Ref 2241.corr.RVBC260619

2241 Winkley Hall Farm, Whalley Road, Hurst Green , BB7 9PN

Application references 3/2026/0094 and 0095

n o r t h e l e v a t i o n

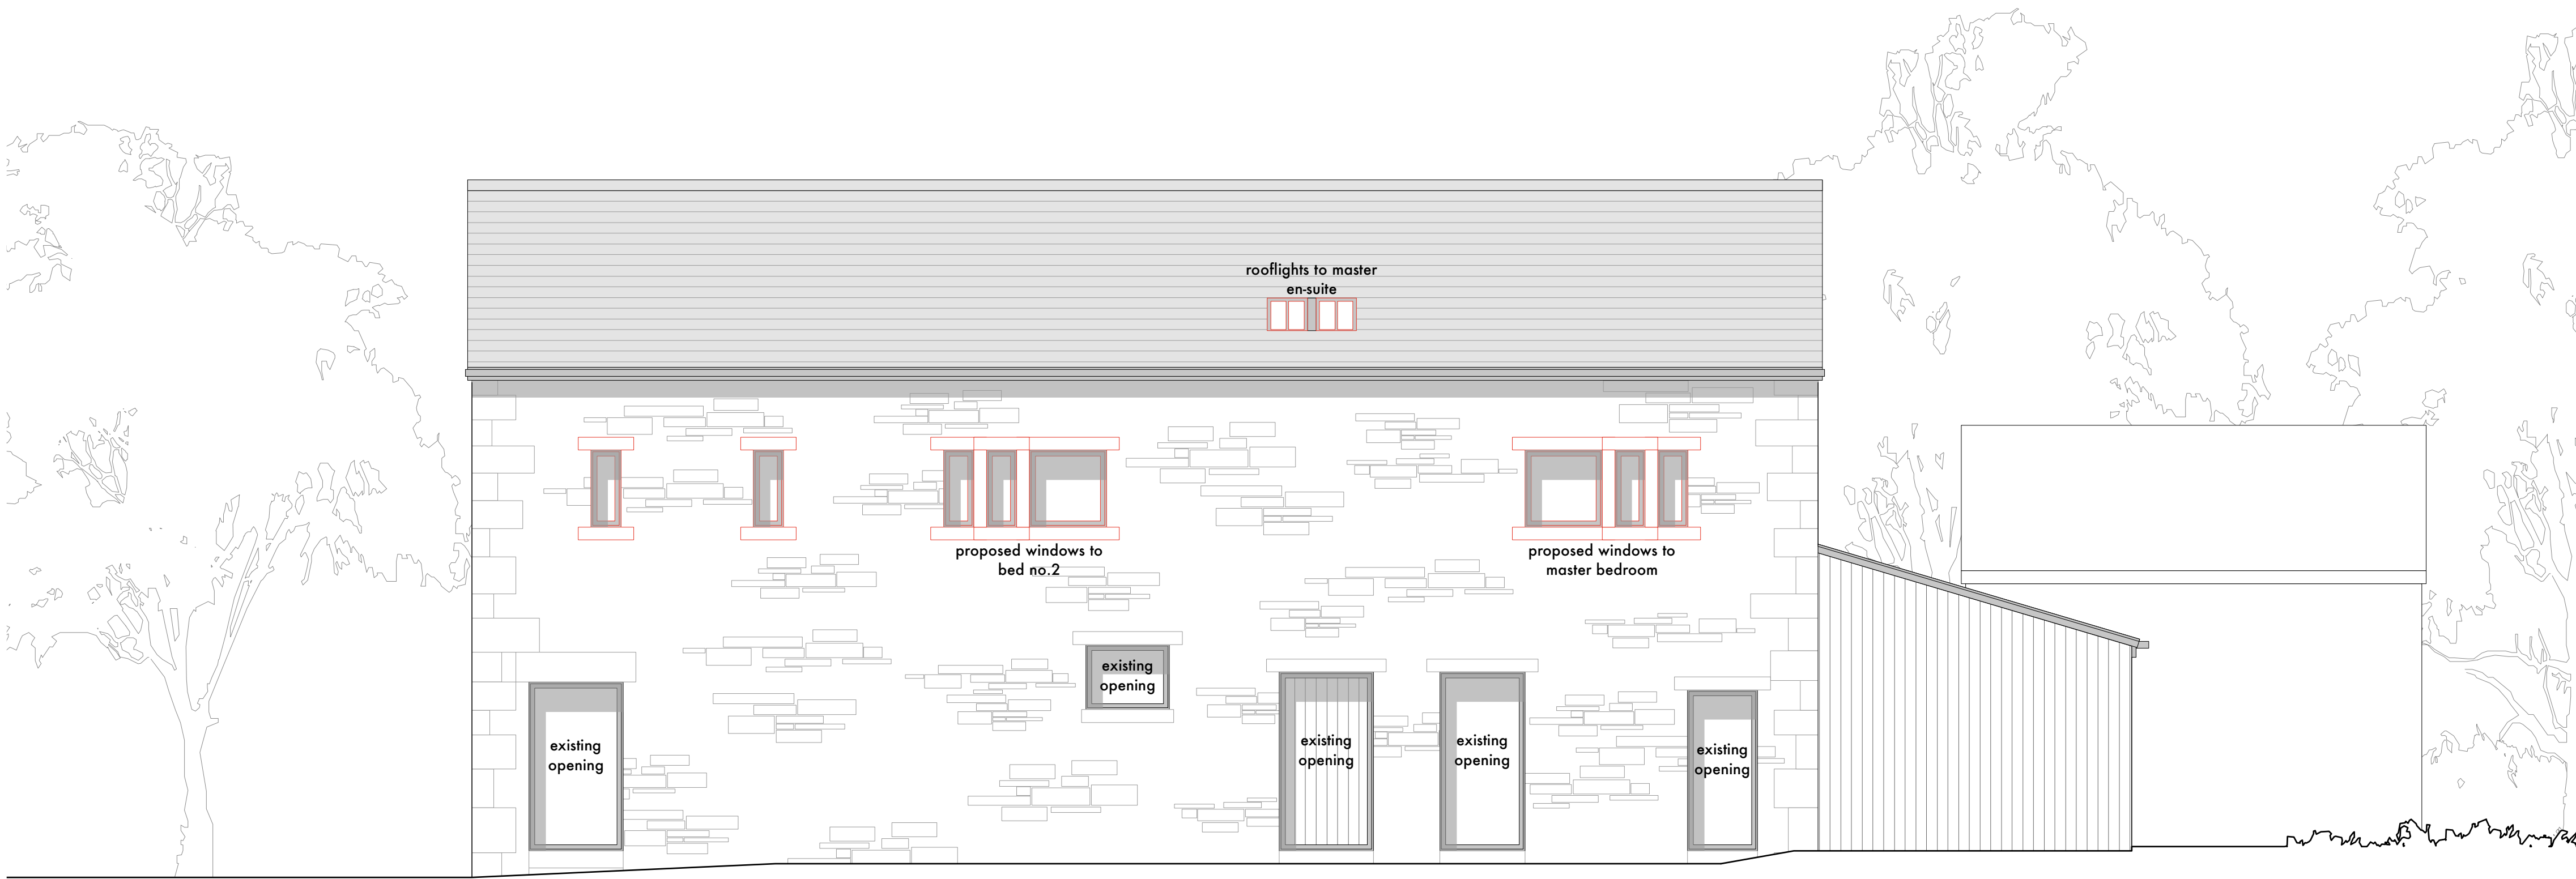
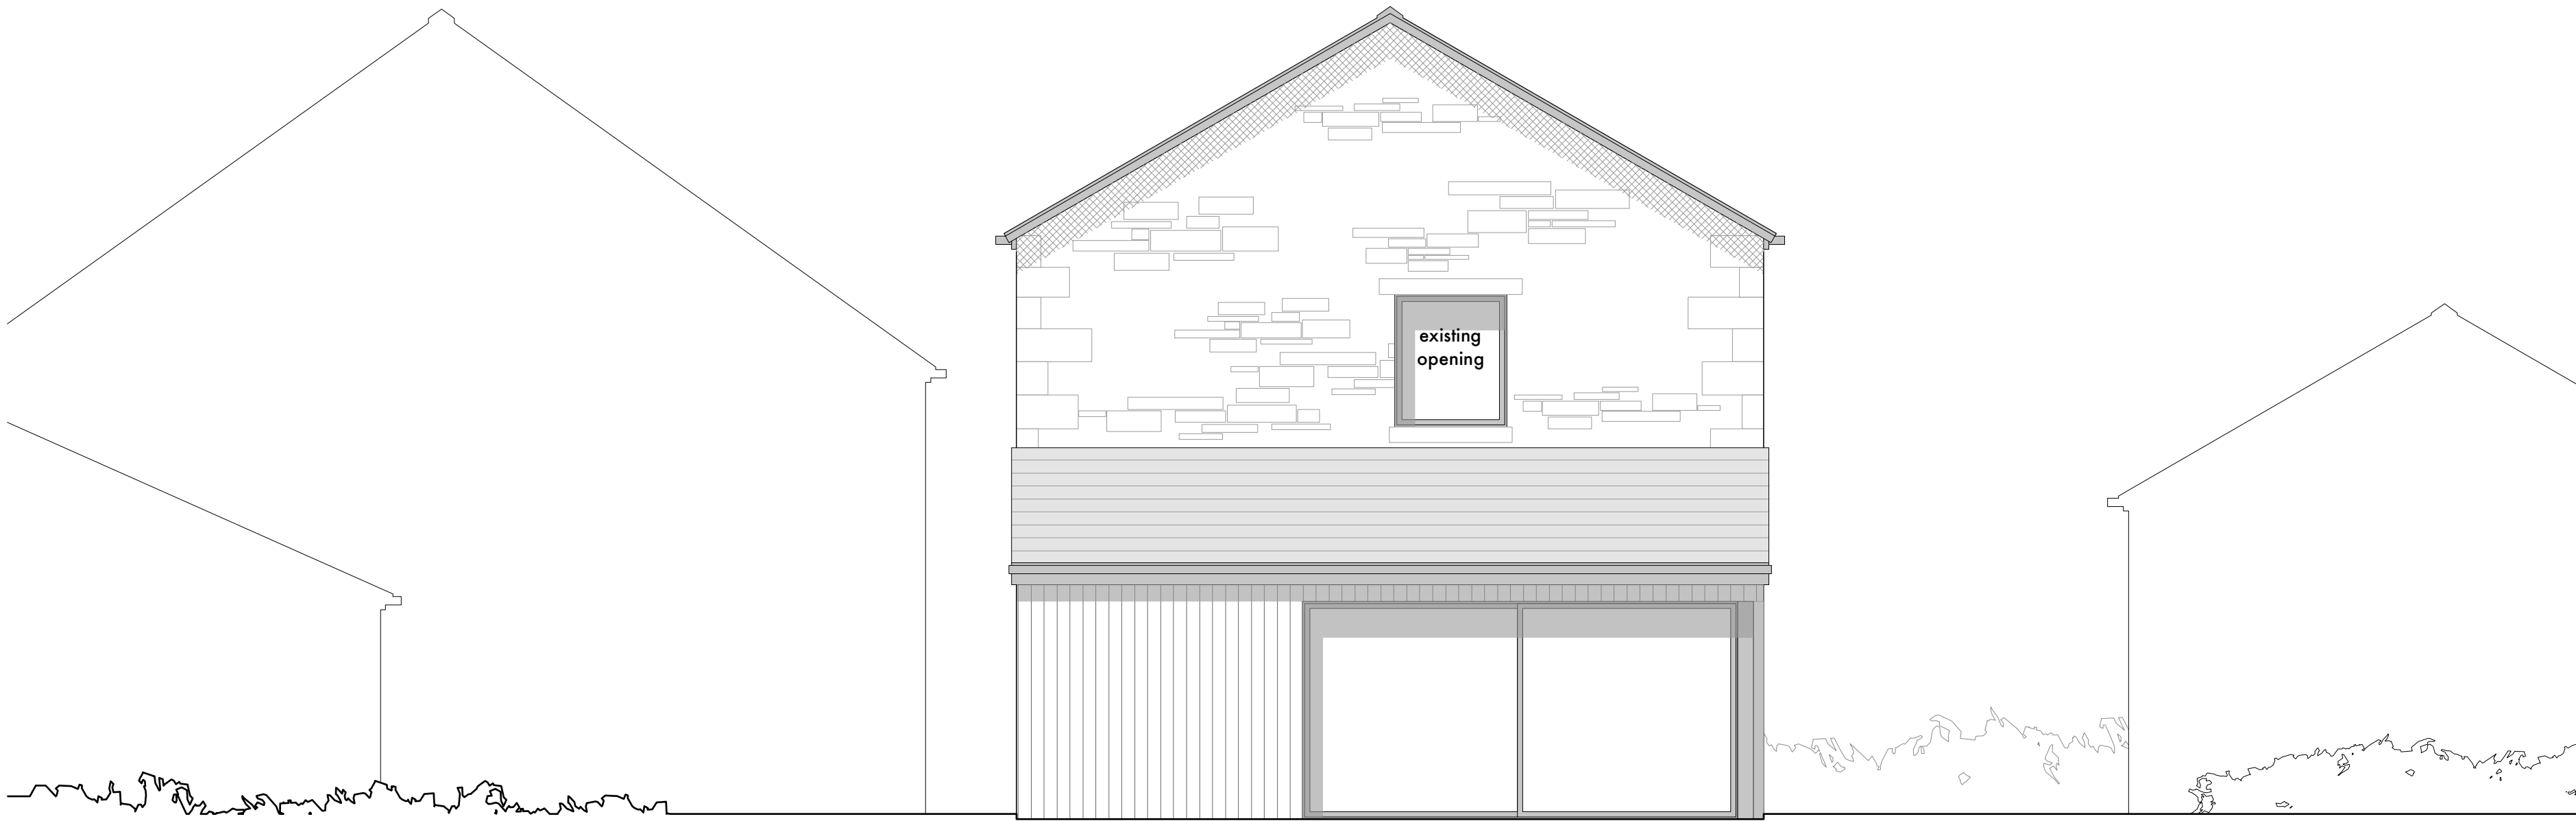
16. Sizing of rooflights reduced as part of the latest proposals. Sizes chosen to suit spacings of existing rafters to avoid the need to cut historic timbers.

south elevation

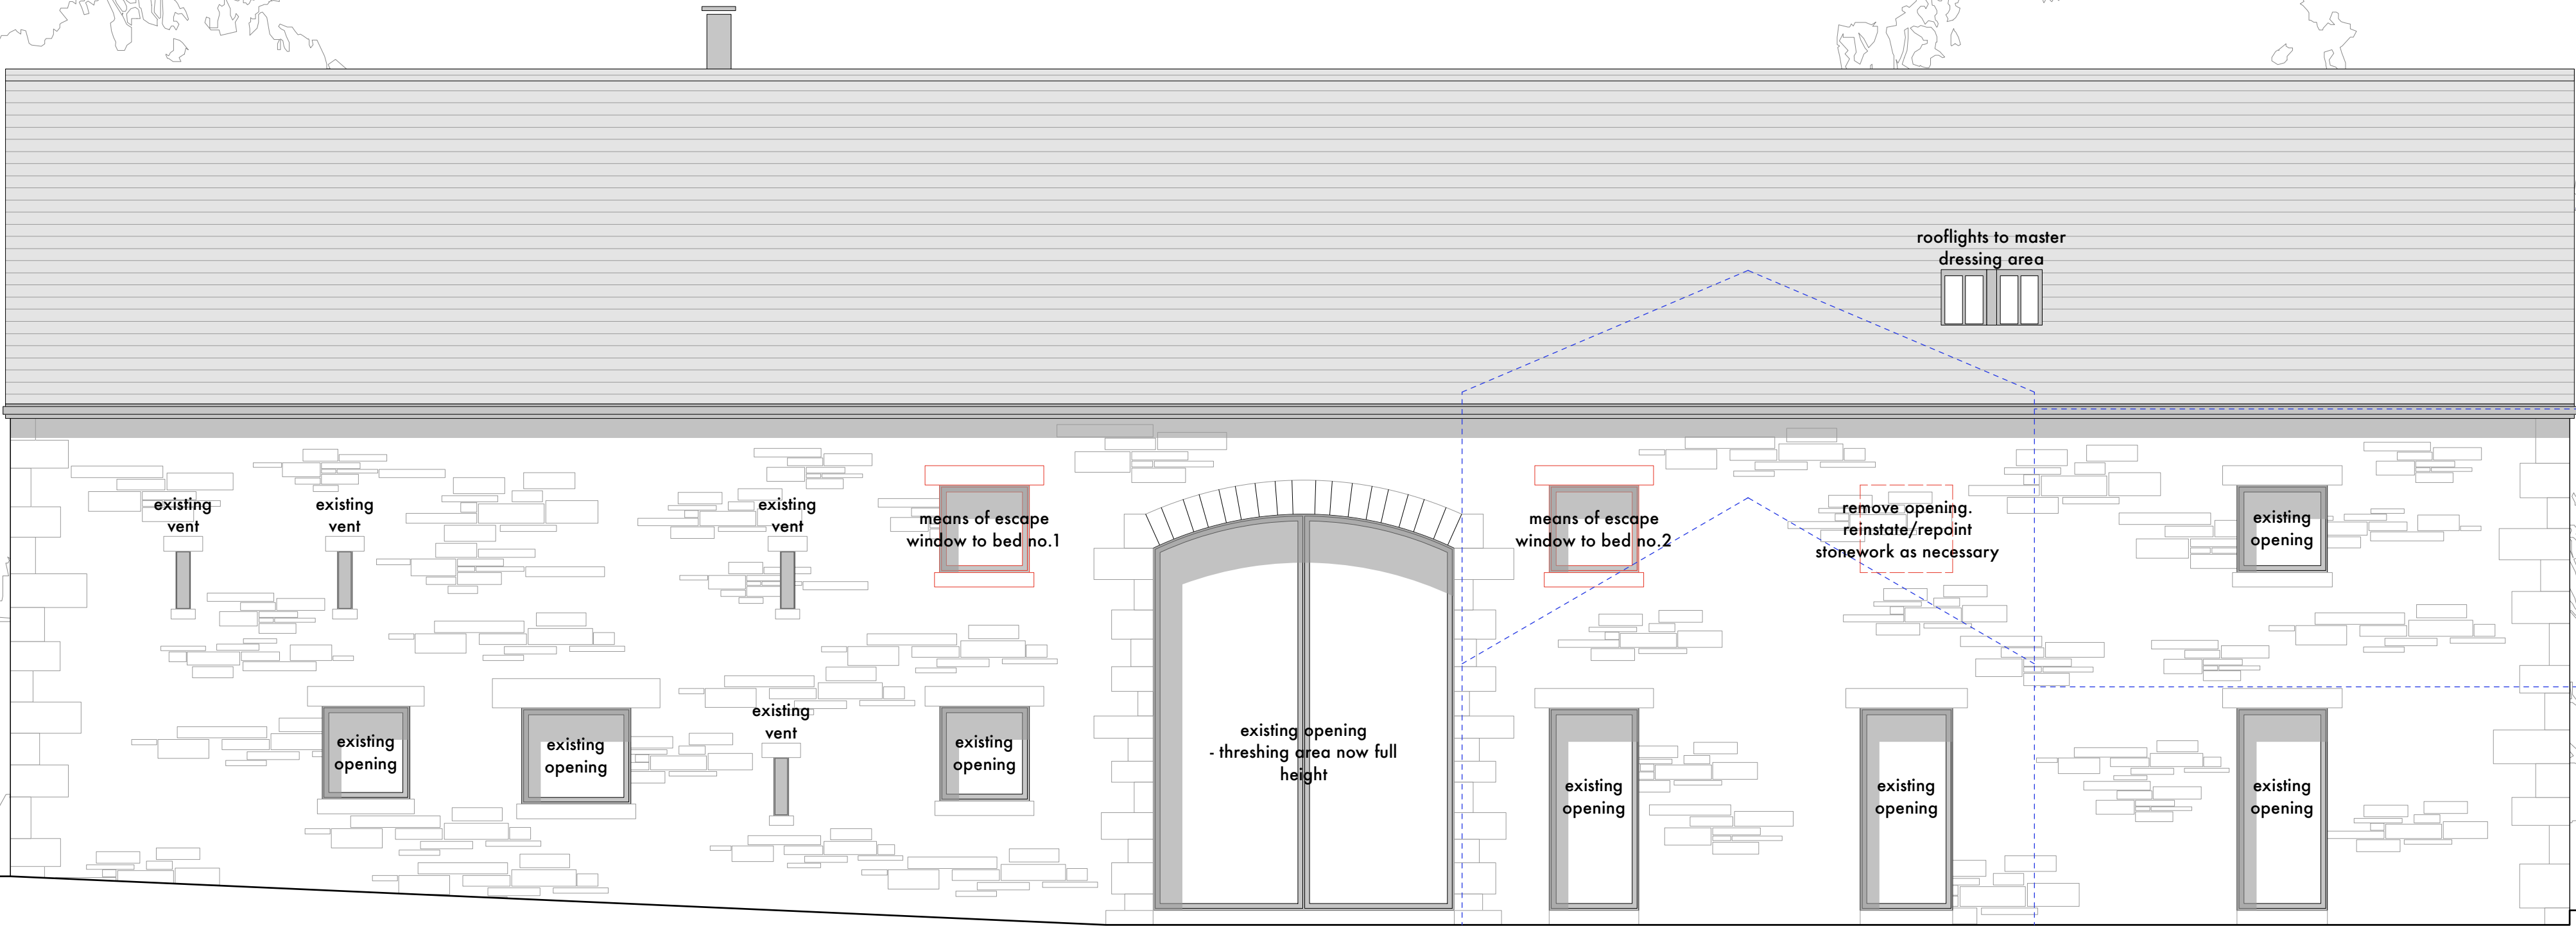
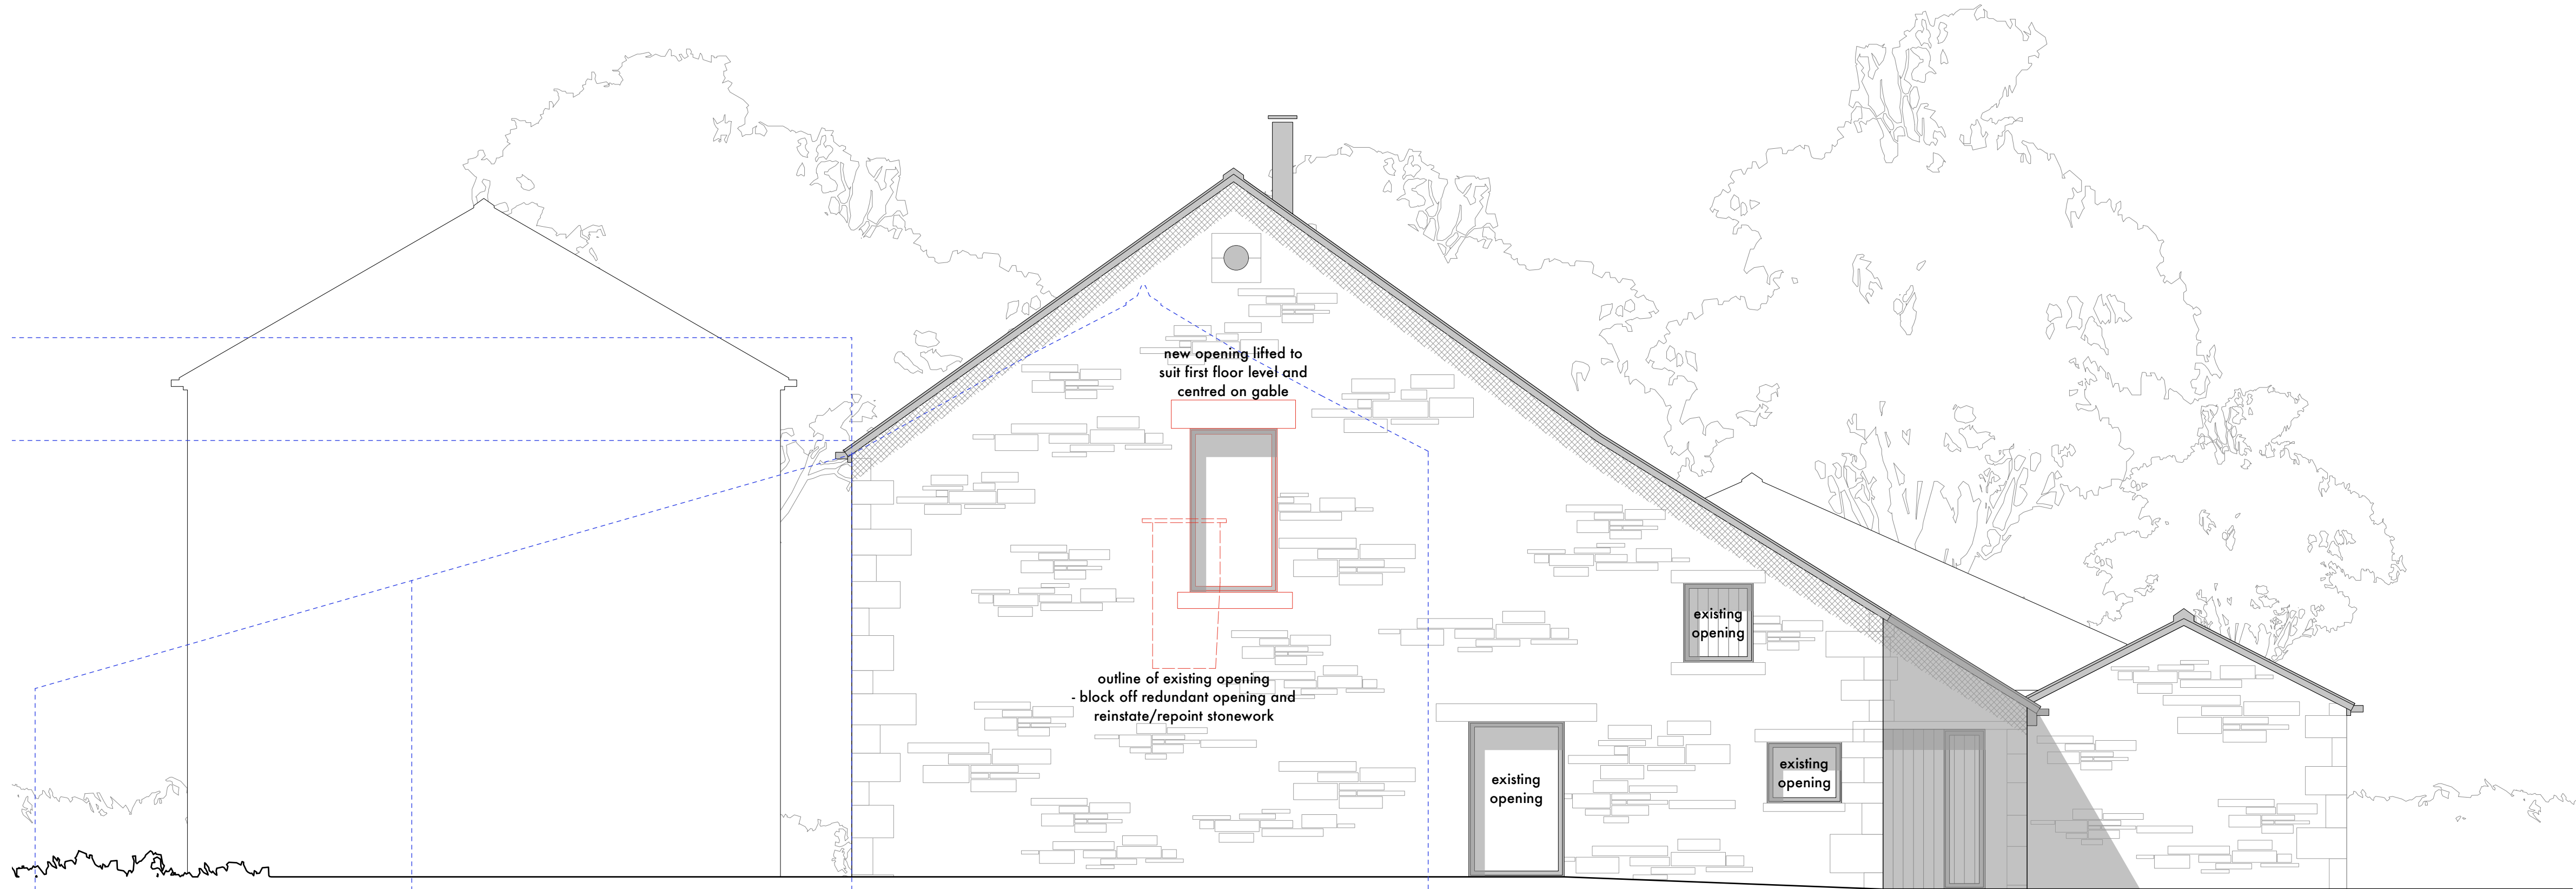
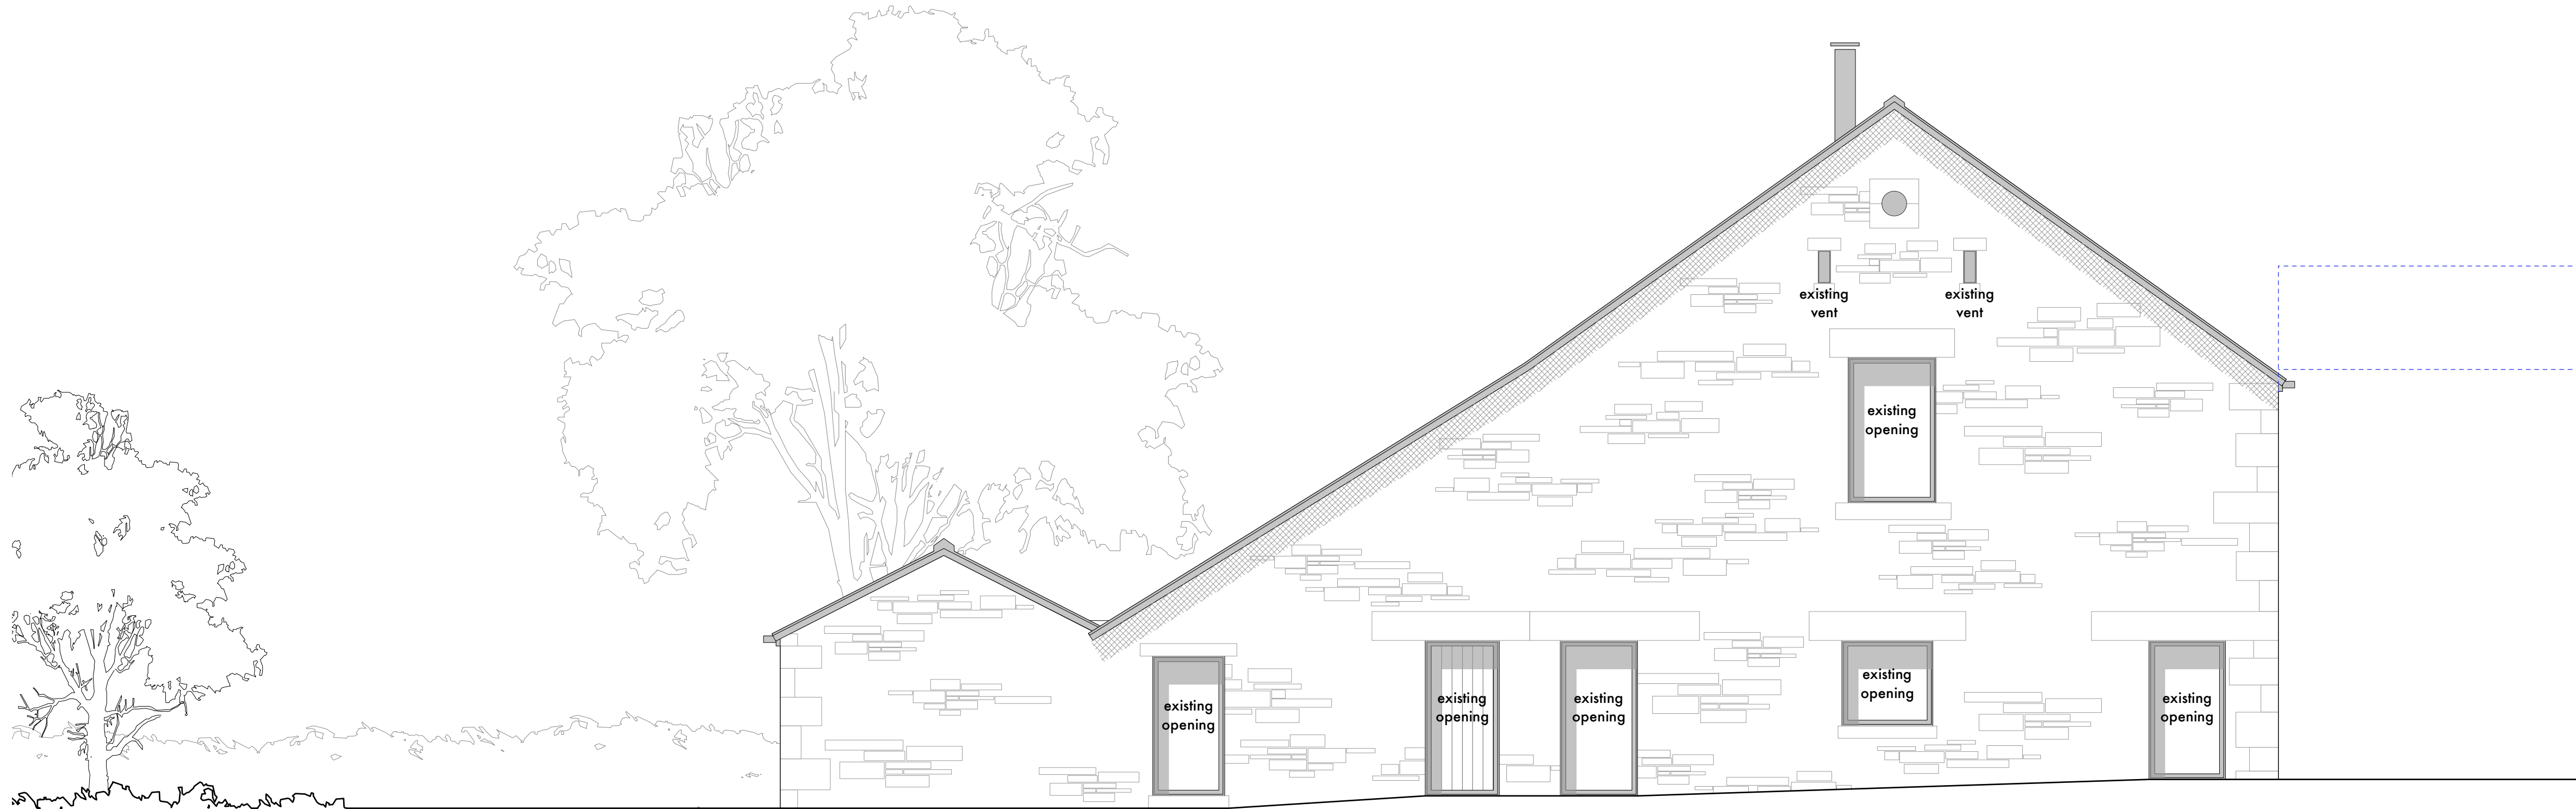
7. Main Barn layout has been re-considered to allow the threshing area to remain open to the ceiling as requested – there are knock-on affects for moving the associated first floor bedroom from this area which includes the need for an additional window to be provided for means of escape (previously provided as part of the sub-divided threshing opening). All illustrated on Main Barn plans/elevations/sections (111-119).
